Rezoning Transportation Analysis

Petition Number: 2024-011

The site is located on a City-maintained, 2+ Avenue Johnston Oehler Road. Based on the 826 daily trips, the petitioner is providing a fee-in lieu for a 12' shared used path. All outstanding CDOT issues have been resolved.

Drawing Title:
Site Details

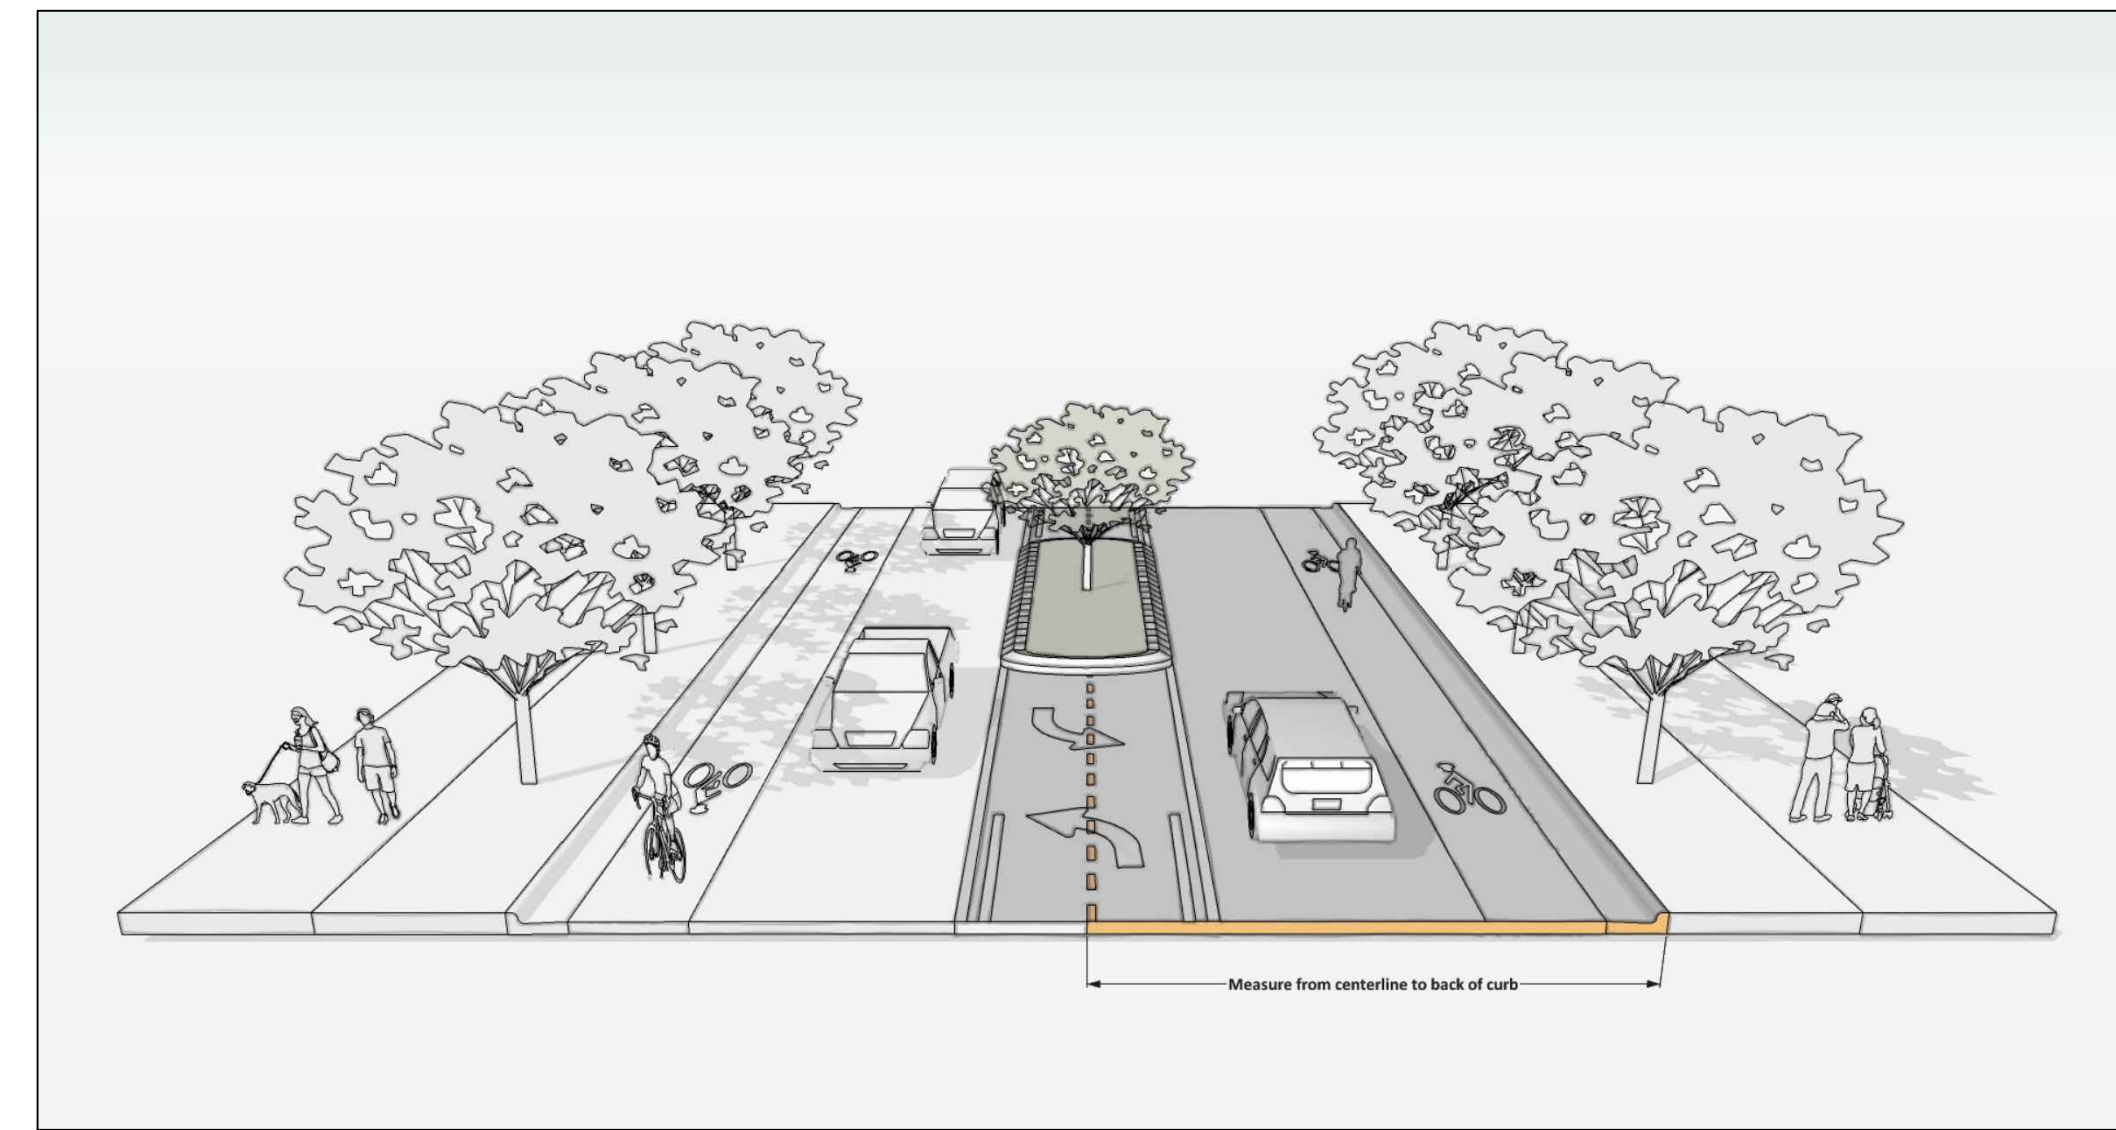
~~Clarifying Comment 05-23-24: Add CTR table with offsite commitments to the site plan.~~

~~Clarifying Comment 03-20-24: An 8 foot planting strip and 8 foot sidewalk are required in N-2 per UDO chapter 33. Revise site plan to commit to installing an 8-foot sidewalk throughout the site on all public roadways.~~

2+ AVENUE ROADWAY PER CHARLOTTE STREETS MAP

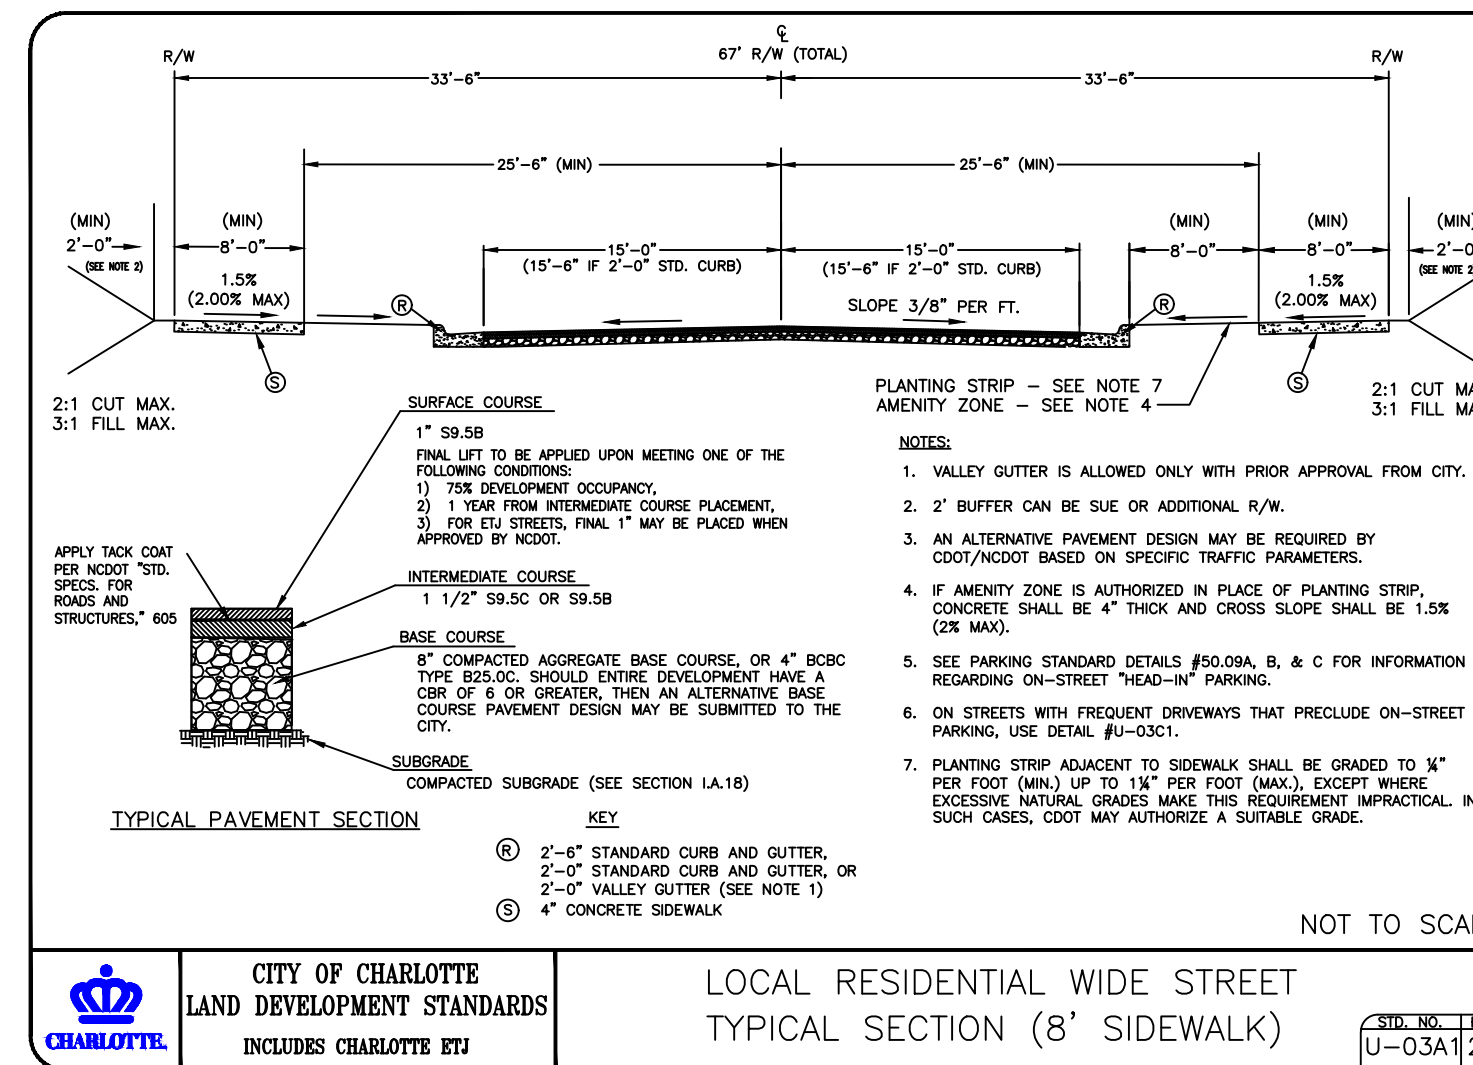
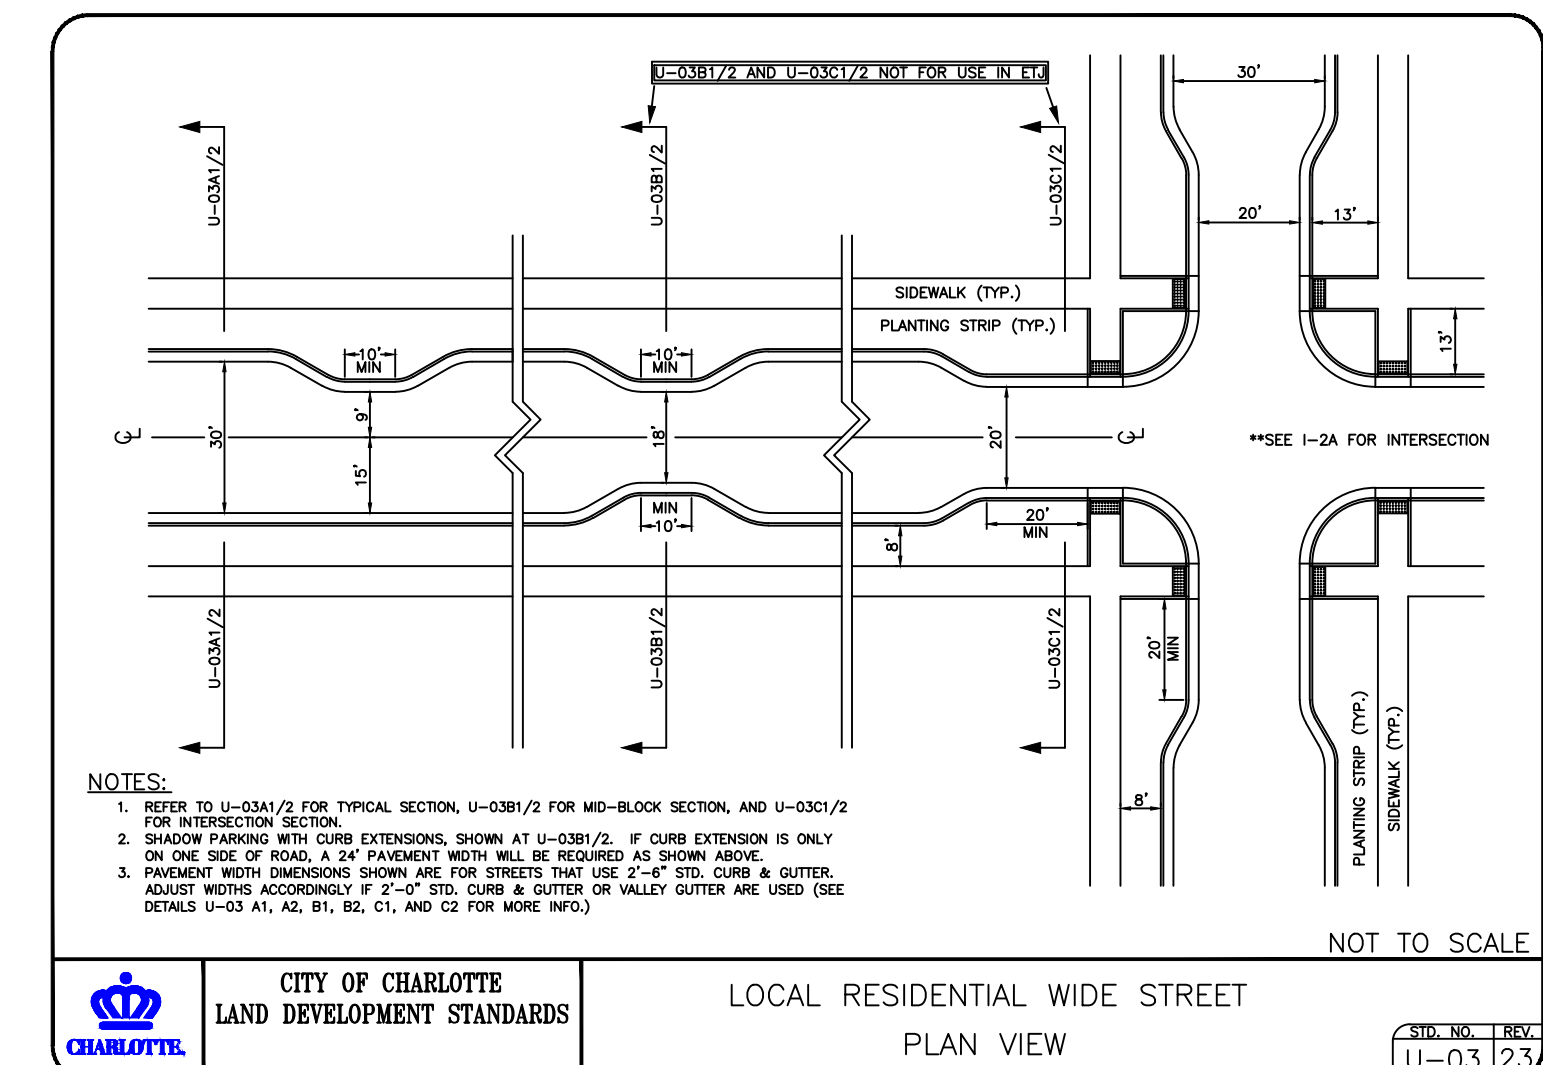
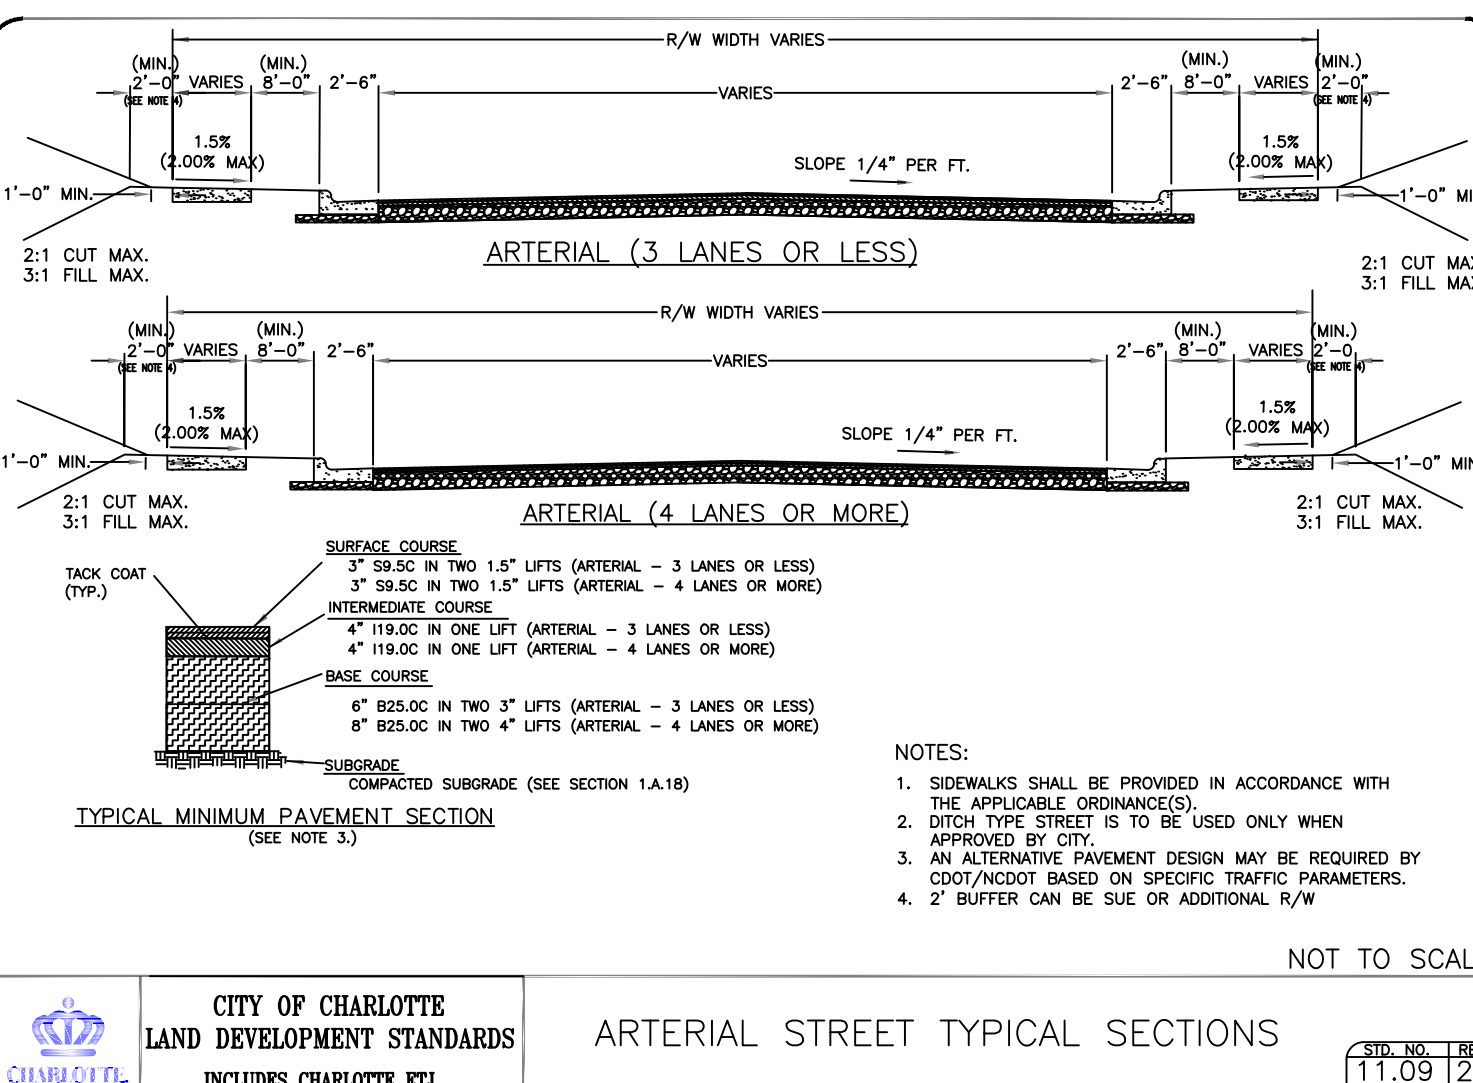
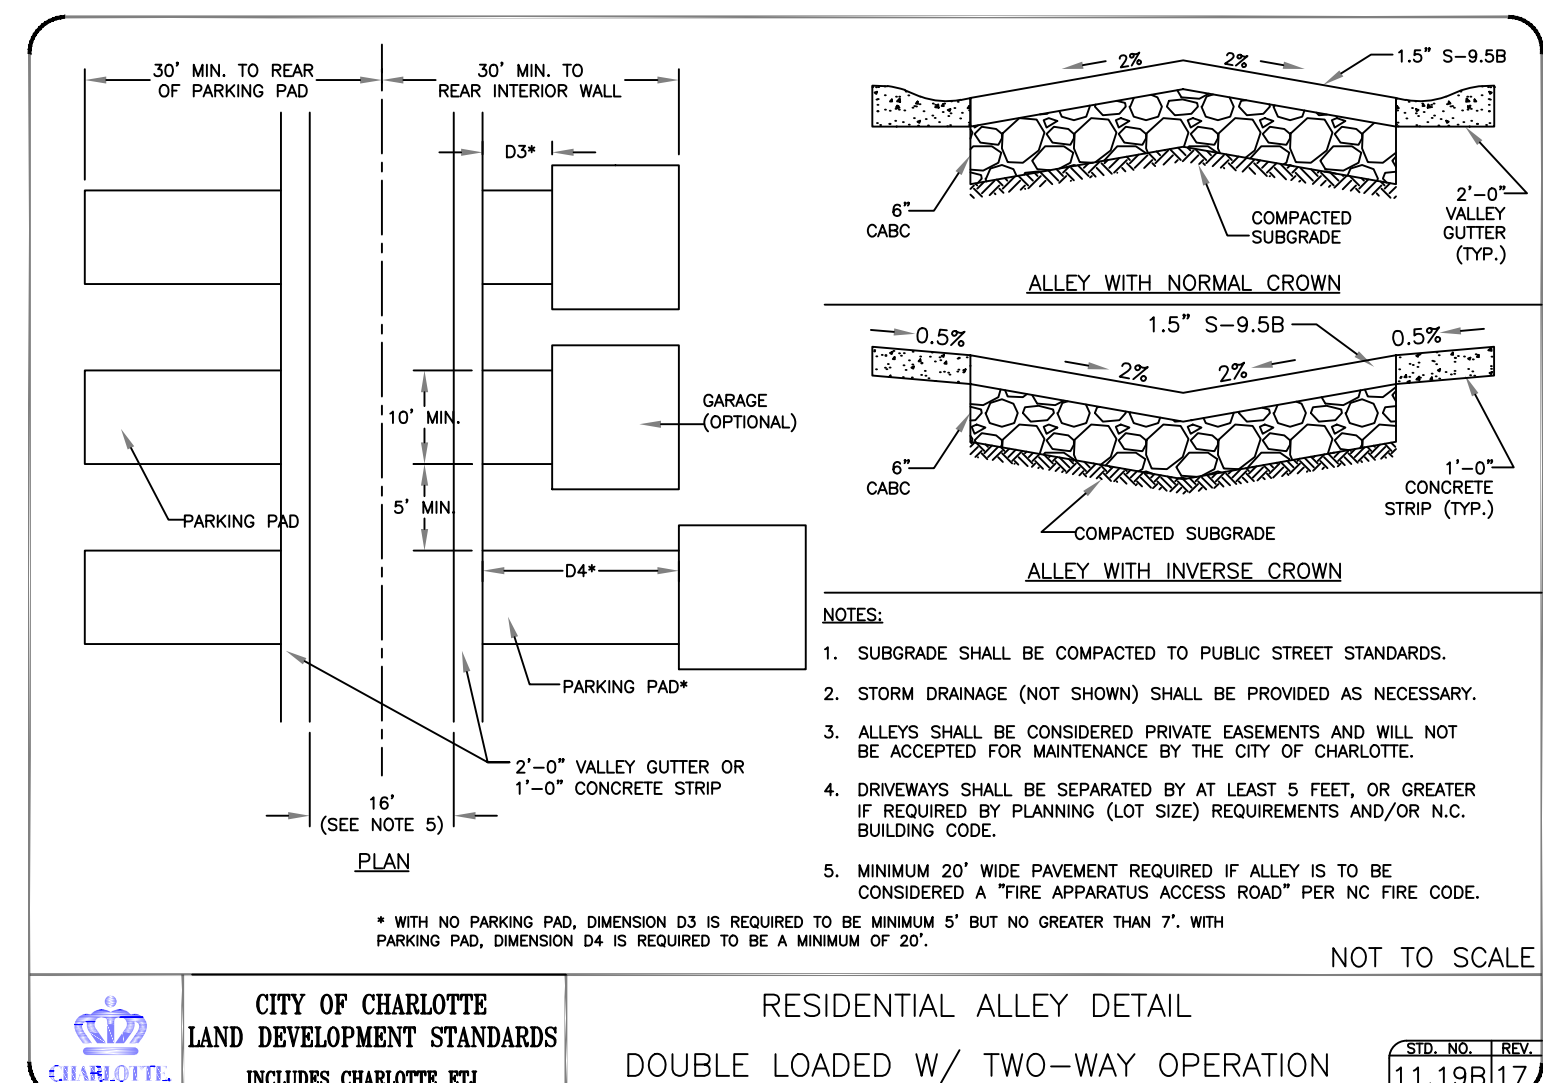
- a. ~~**Johnston Oehler Road:** Location of future curb and gutter is to be relocated to 24 feet from the roadway centerline. Per CLDSM 11.09.~~

Label and dimension the curb and gutter from the centerline for each road on the site plan.
